Markup Summary

**ANTELOPE ACRES FILING NO. 1A**  
A REPLAT OF LOTS 13 & 14, "ANTELOPE ACRES"  
A PORTION OF THE NE 1/4 OF SECTION 30,  
TOWNSHIP 14 SOUTH, RANGE 62 WEST OF THE 6TH P.M.,  
EL PASO COUNTY, COLORADO

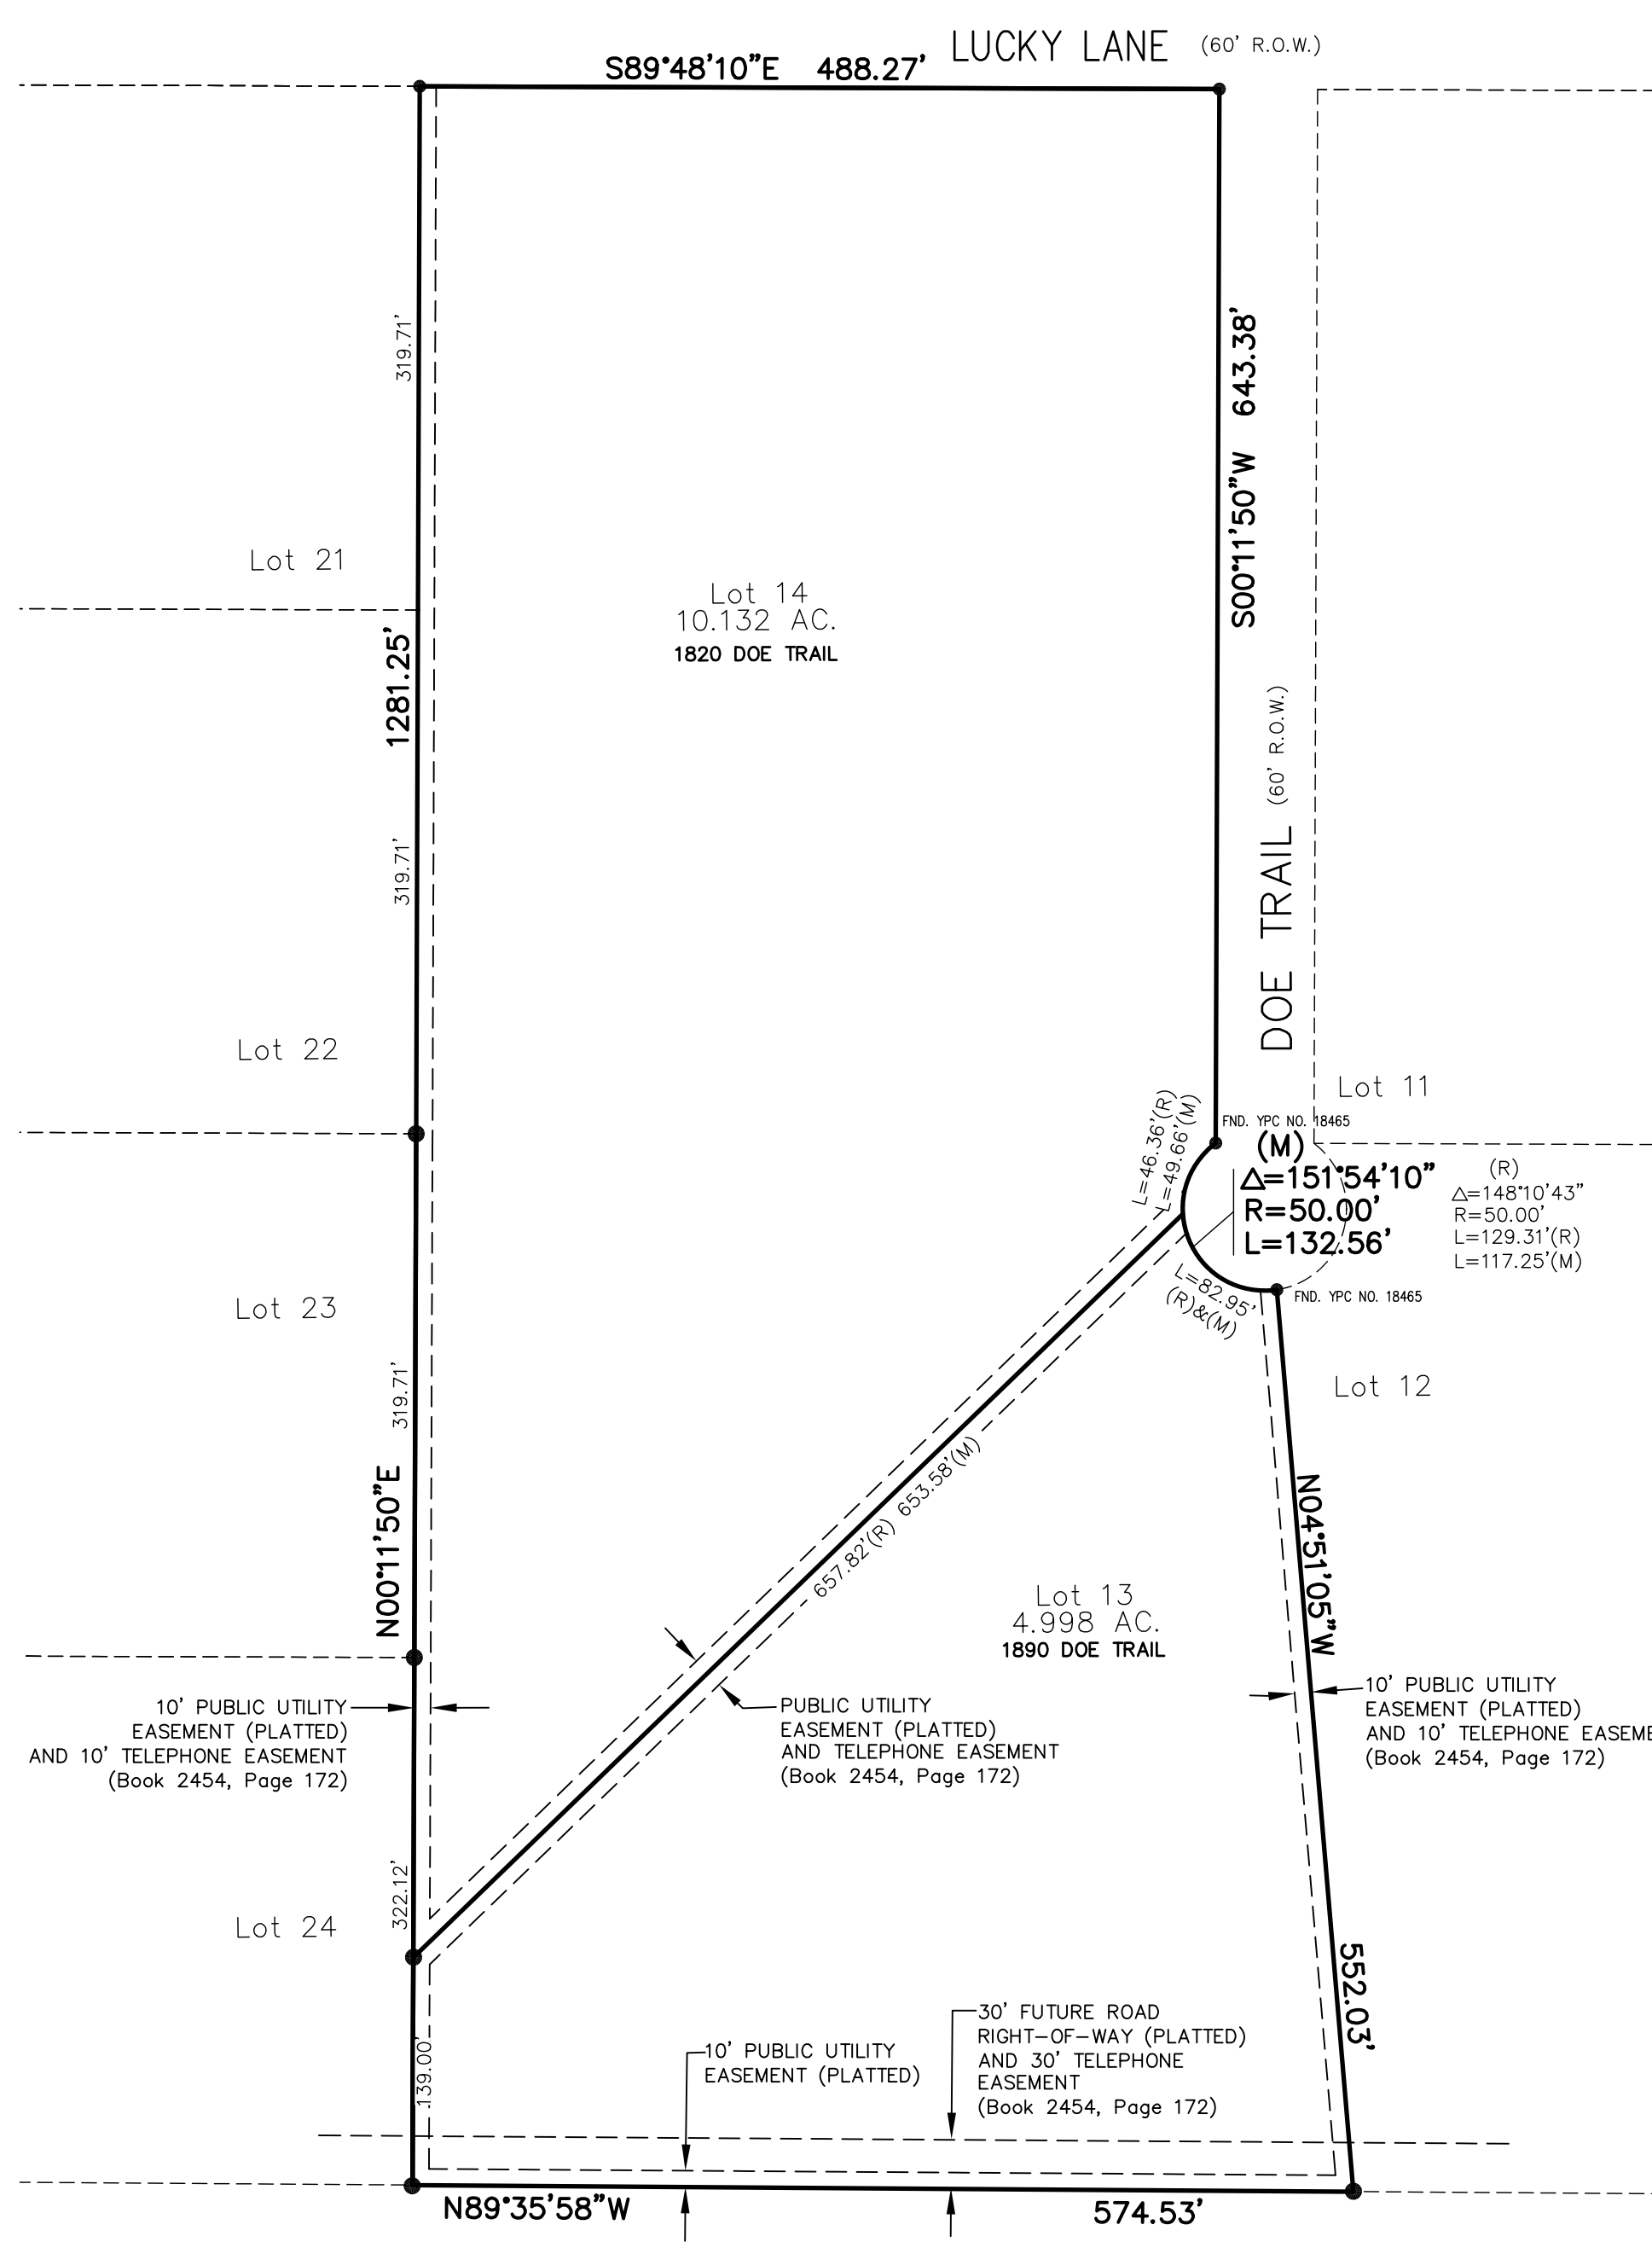
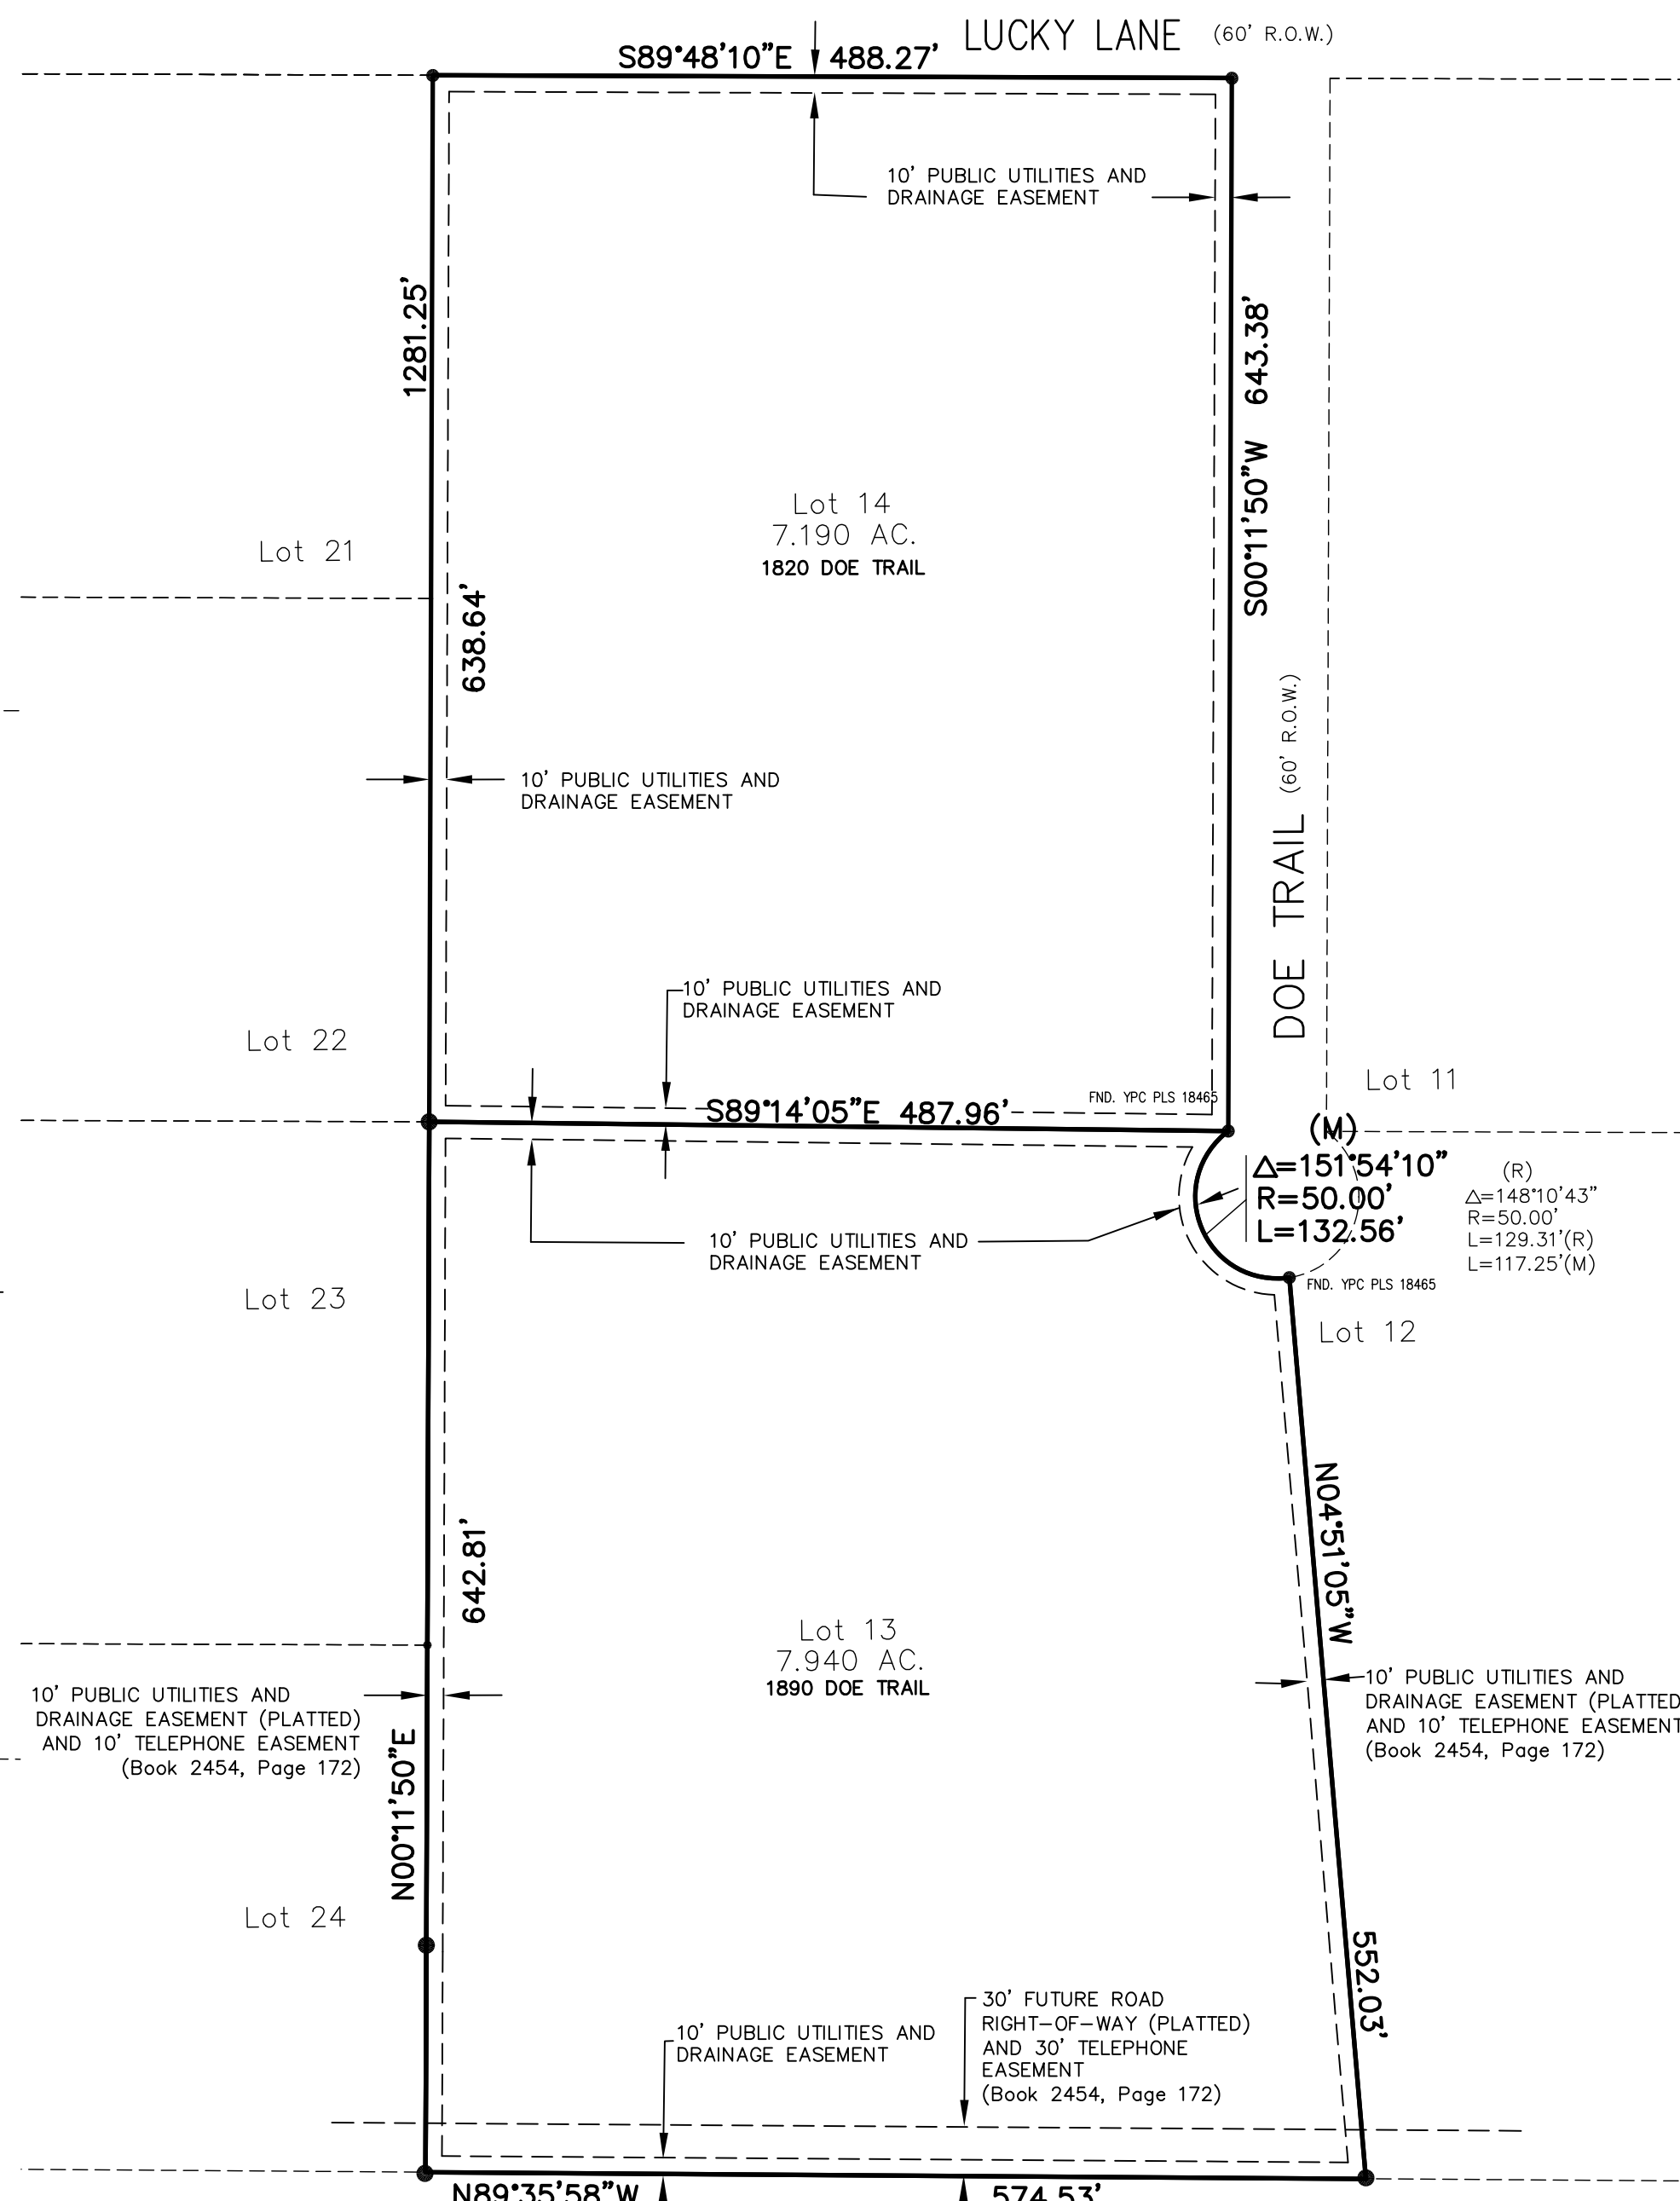
Revise all reference from City of Colorado Springs to El Paso County.

Provide and show 10' Public Utility and Drainage Easement along the front lot lines.

update callout to provide drainage easement.

Update. Does not match the sum of the two lots.

Incorrect signature block, this is for recording

Note 1 needs to specify the reason for the vacation and replat

Owner of easement must approve the vacation of this easement

Add the following notes:

1. All property owners are responsible for maintaining proper storm water drainage in and through their property. Public drainage easements as specifically noted on the plat shall be maintained by the individual lot owners unless otherwise indicated. Structures, fences, materials or landscaping that could impede the flow of runoff shall not be placed in drainage easements.

2. Unless otherwise indicated, all side, front, and rear lot lines are hereby platted on either side with a 10 foot public utility and drainage easement unless otherwise indicated. The sole responsibility for maintenance of these easements is hereby vested with the individual property owners.

3. No driveway shall be established unless an access permit has been granted by El Paso County.
